**Washington State  
Department of Transportation**  
**Douglas B. MacDonald**  
Secretary of Transportation

April 23, 2010

RE: Marian Meadows Planned Unit Development and Subdivision Draft Environmental Impact Statement

MARTAN MEADOWS
PRELIMINARY PLAN
SEC. 1 & 12, TWP. 20 N., RNG 13 E., W.M.
KITTAS COUNTY, WASHINGTON
PHASING AND TOTAL SITE PLAN

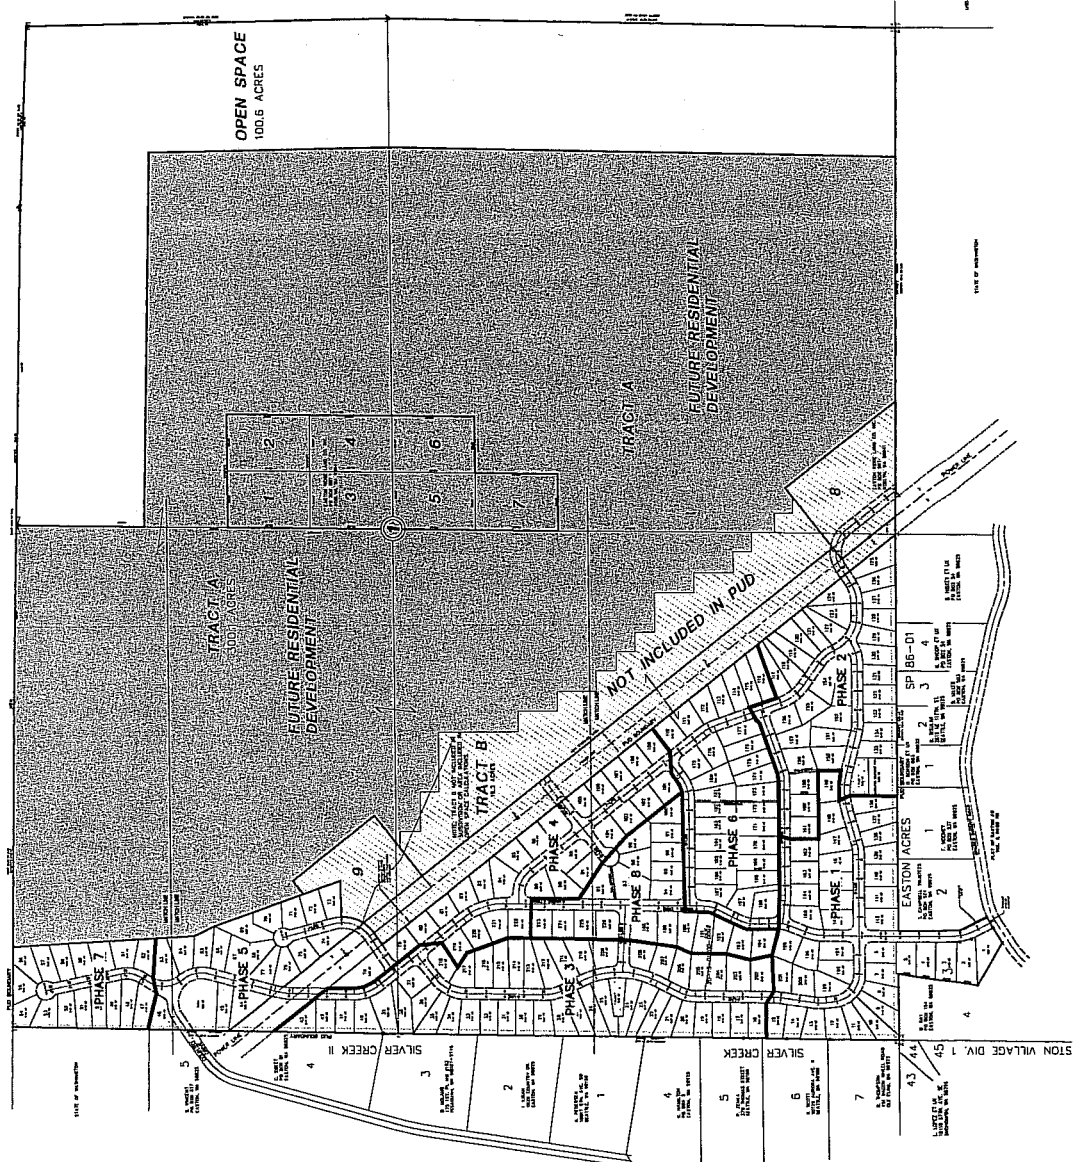
**Alternatives 1, 2, 4 and 5:** propose an incompatible residential density, and are inconsistent with state law, and the goals and policies of Kittitas County.

**Alternative 3:** The density proposed in alternative 3 exceeds recommend residential density found in WSDOT's Airports and Compatible Land Use Vol. This alternative places single-family residential development in the approach to Easton State Airport.

- The majority of off-airport accidents occur along the extended runway centerline during the approach and departure phases of flight. The EIS should address this fact.
- All alternatives exceeded recommended residential densities
- The airport is often used as an emergency landing facility
